Applicant: Mr Wayne Hadfield

Description: Use of land for hand car wash including staff room and staff and visitor parking.

Site Address: Land adjacent to Three T's Industrial Estate, Platts Common Industrial Estate, Platts Common, Barnsley, S74 9DG

Drawing Title
SITE PLANS

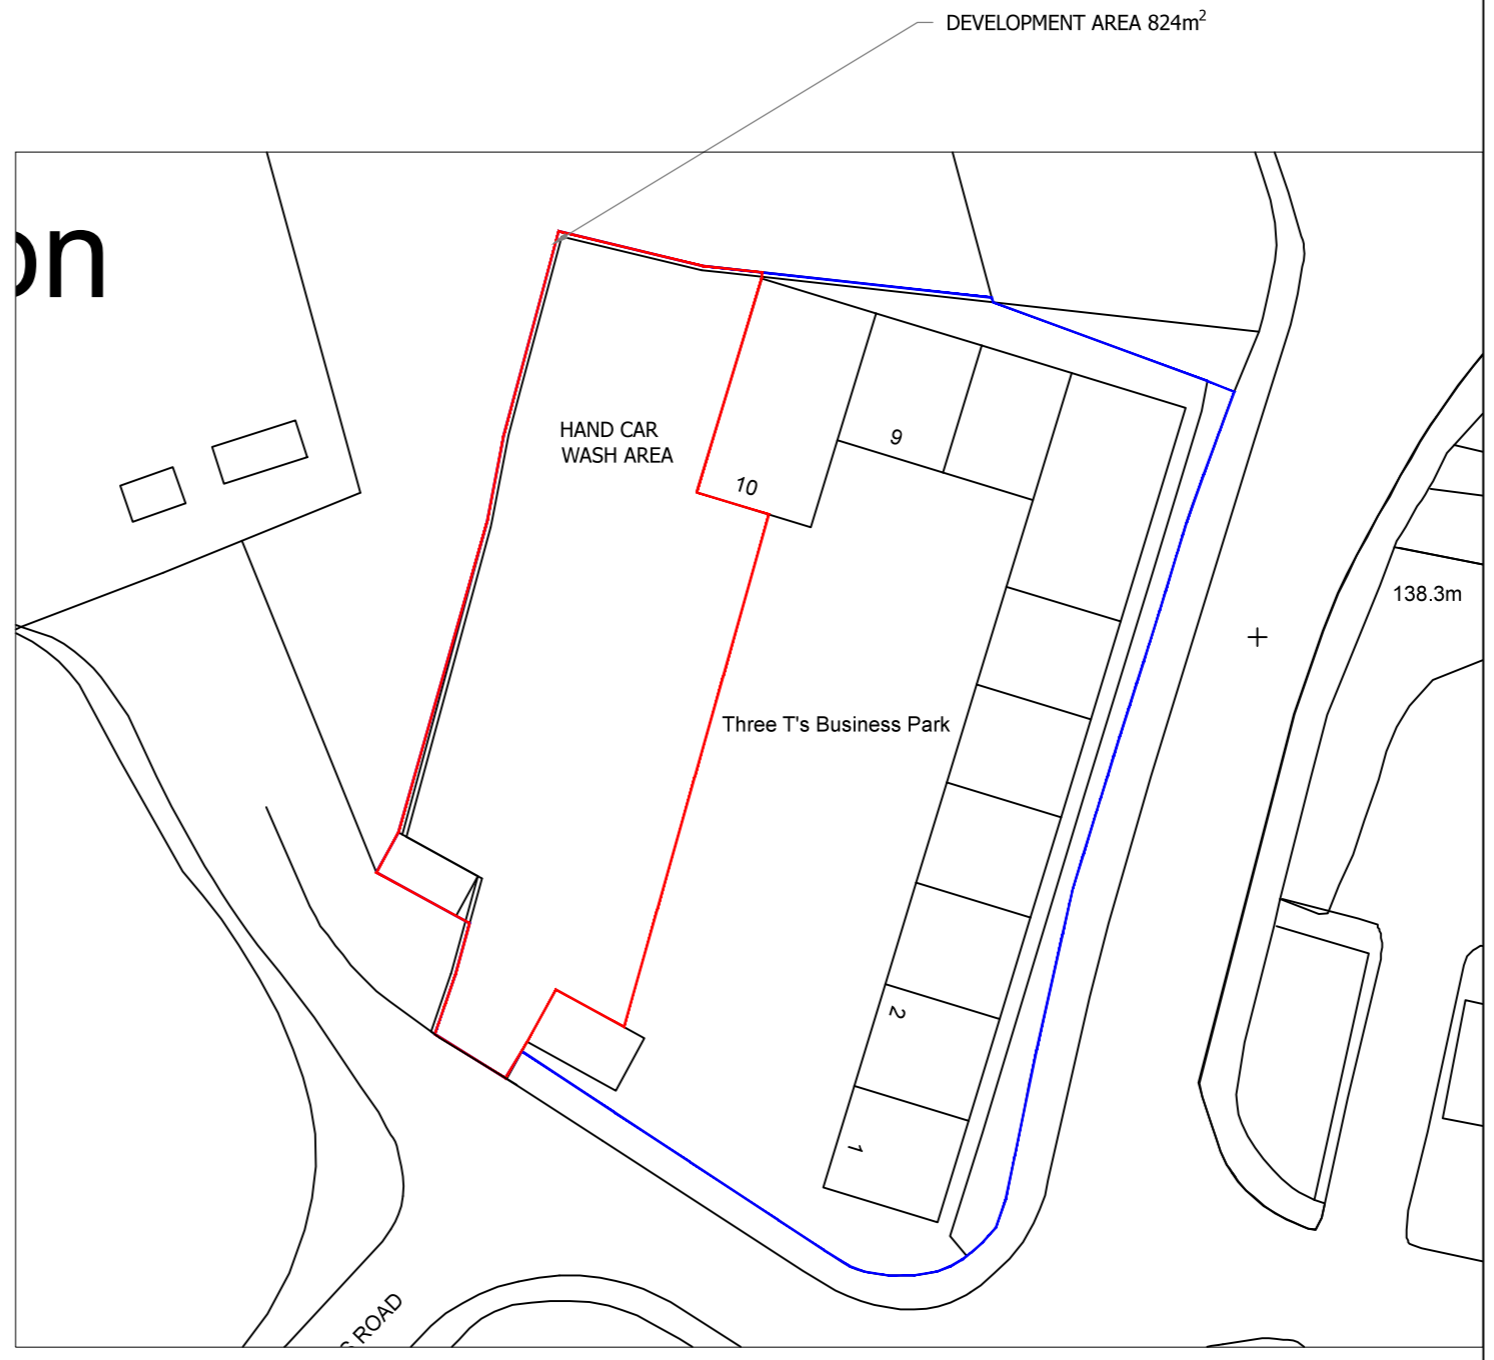
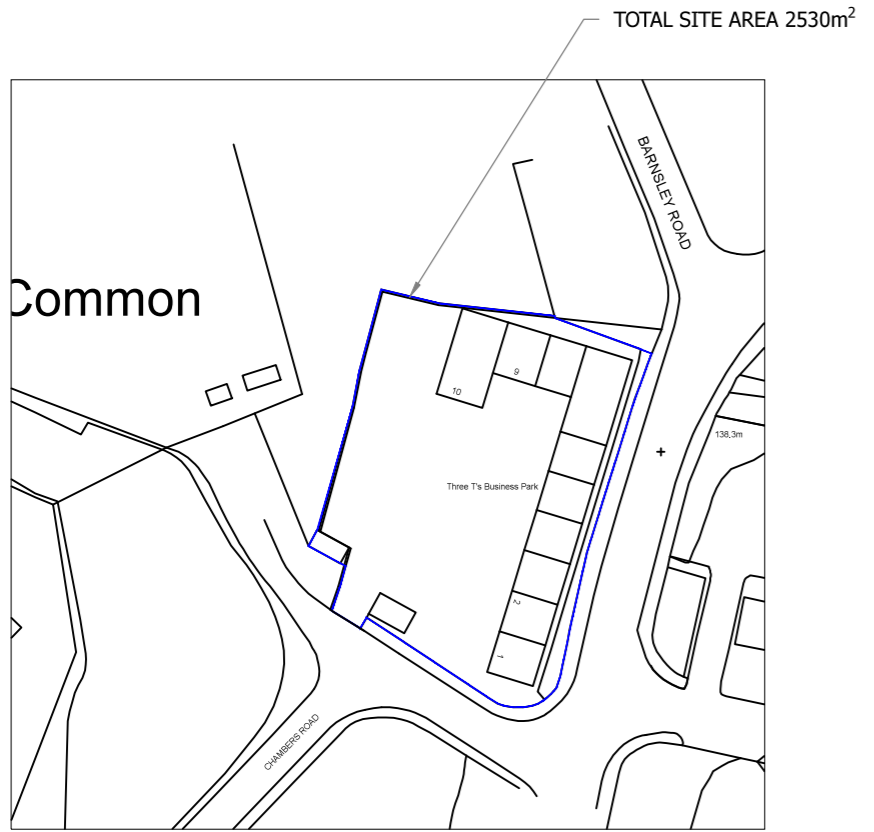
As with the previously refused application, a single access and exit point direct from Chambers Road is proposed. The previous area allocated for queueing cars and staff/visitor parking has been omitted on this application. The applicant does propose a staff and customer parking area, however, it encroaches into the parking/manoeuvring area of the neighbouring business park. The owner of several of the units of the business park states the applicant has no control over that land. Furthermore, the majority of the redline boundary is within Council ownership, as such, as with the previously refused scheme, the current proposal heavily relies on land outside of the applicants' ownership or control.

The extent of the ownership/control above demonstrates that the site cannot be accessed unless crossing Council owned land, the majority of the area of the hand car wash is partially within Council ownership, the area of the Three T's Business Park needed to widen the hand car wash is within Council Ownership. Furthermore, the area required for staff/visitor parking within the Three T's business park is also claimed to be outside of the applicants control and in separate ownership. As such, without that land the applicant cannot safely access or operate the proposed use, therefore, there is no reasonable expectation that the development could be implemented.

As outlined above, there is extensive history to this site and a previous application for the hand car wash recently refused. Arguably this application has taken a backward step from the previously refused application as the area of land previously included for queueing and parking has been lost, resulting in queueing now taking place on Chambers Road. The applicant is proposing staff parking within the site however, on land which encroaches into the adjoining industrial estate. This evidently impacts both the parking within the industrial estate and reduces the available space for vehicles to turn within the site.

The changes proposed under this application do not address the previously raised concerns and additionally, now negatively impact the adjoining industrial estate. As such, Highways DM continue to raise objection to the application from a highways perspective.

Taking the above into consideration, the application is not viewed favourably in terms of highway safety. The proposal is over intensive for the site with the potential for conflicting vehicle movements impacting the free flow of traffic on the highway network. The proposal is therefore contrary to Local Plan Policy T4 and paragraphs 114 and 115 of the NPPF.

PROPOSED ELEVATION OF ACOUSTIC SCREEN
SCALE NTS AT A3

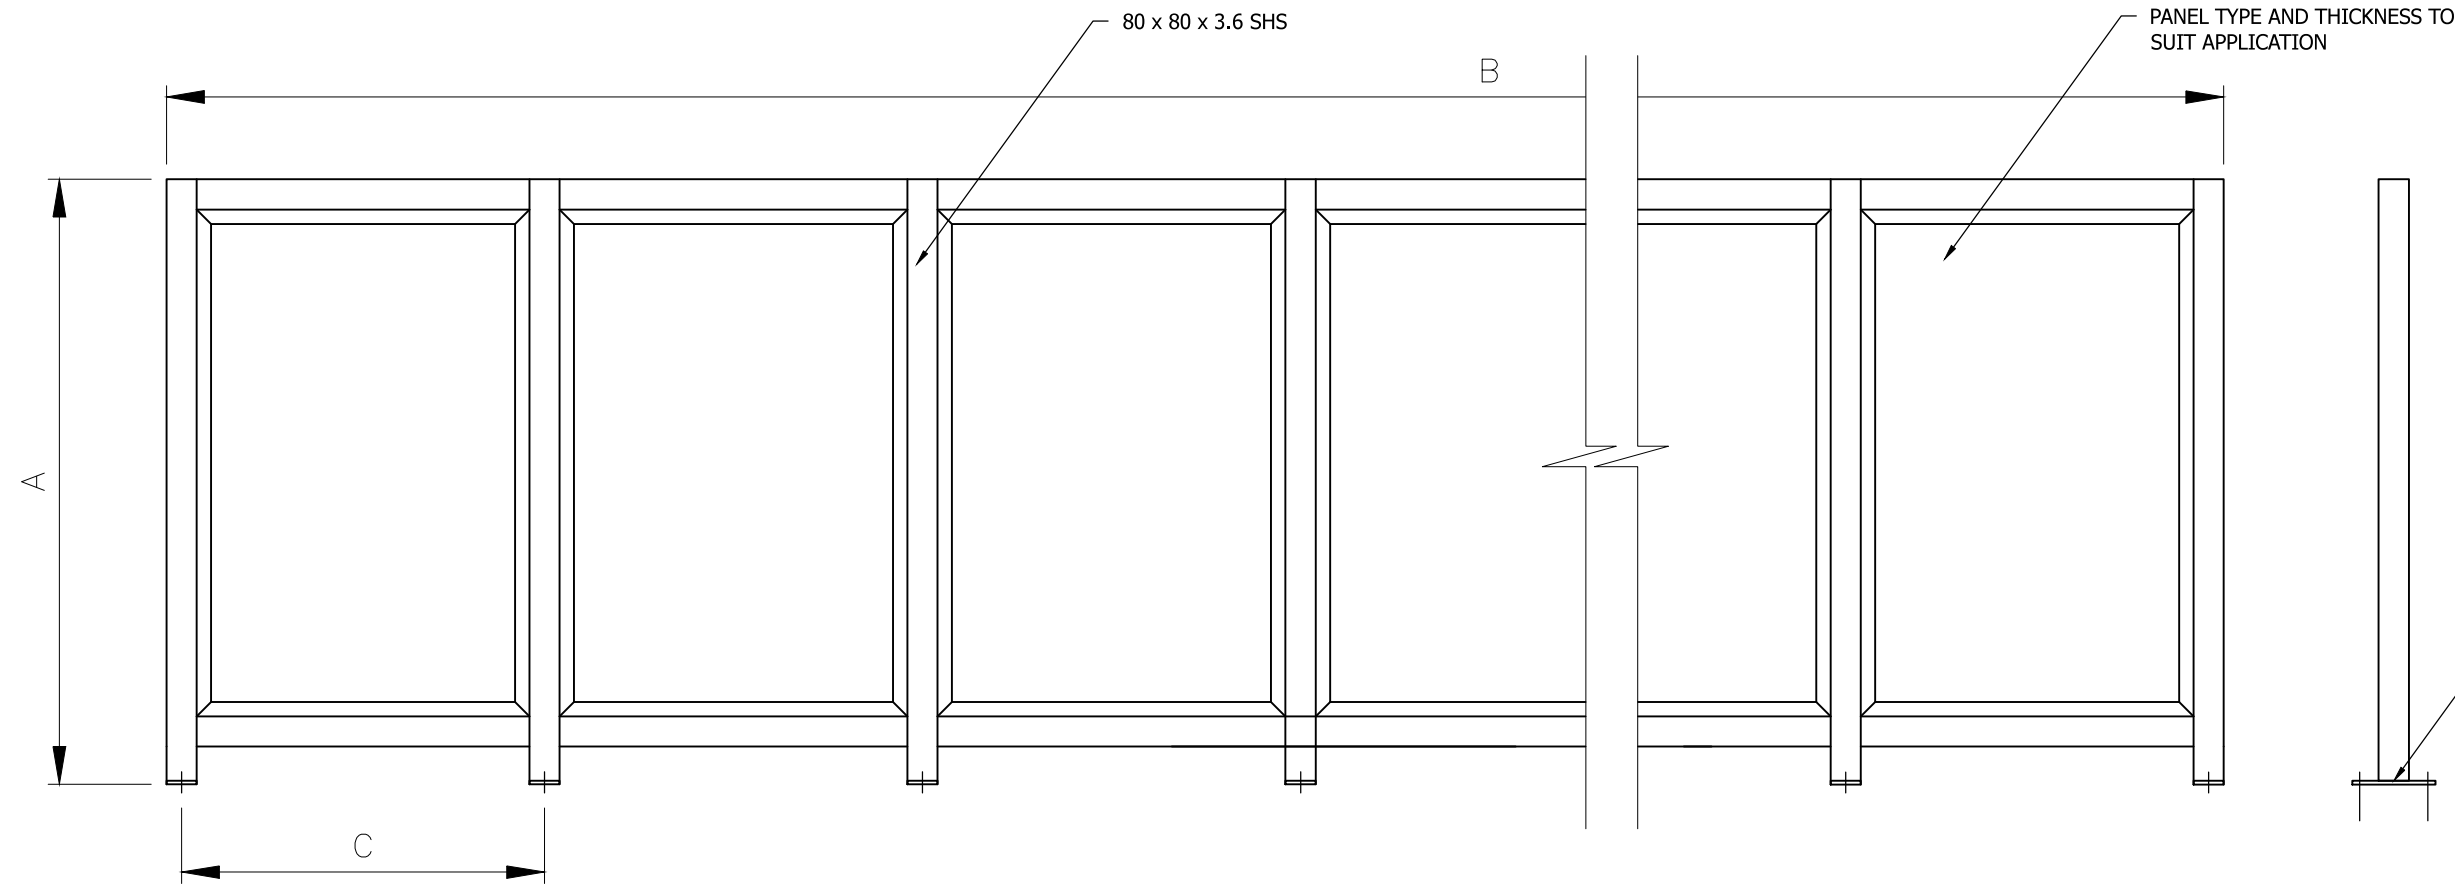
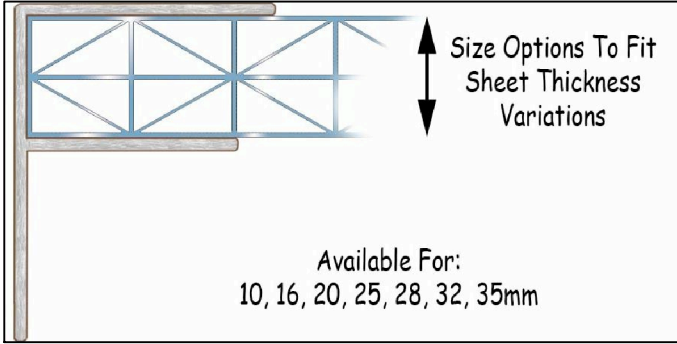
However, the site is immediately adjacent to a number of business units and could negatively impact the occupants of those units. Apart from a Jet Wash specification sheet and an indication that a small section of acoustic screen would be erected, no information has been supplied relating to what equipment will be used, what noise levels will be emitted and how any noise will be mitigated. There is also no information in terms of protecting the neighbouring units from any over spray that may occur.

In this case it is considered that there is a lack of information available to fully consider the proposal, its potential impact on neighbouring users and any mitigation measures which may be required, contrary to local Plan Policies GD1 and Poll 1 and NPPF paragraph 191.
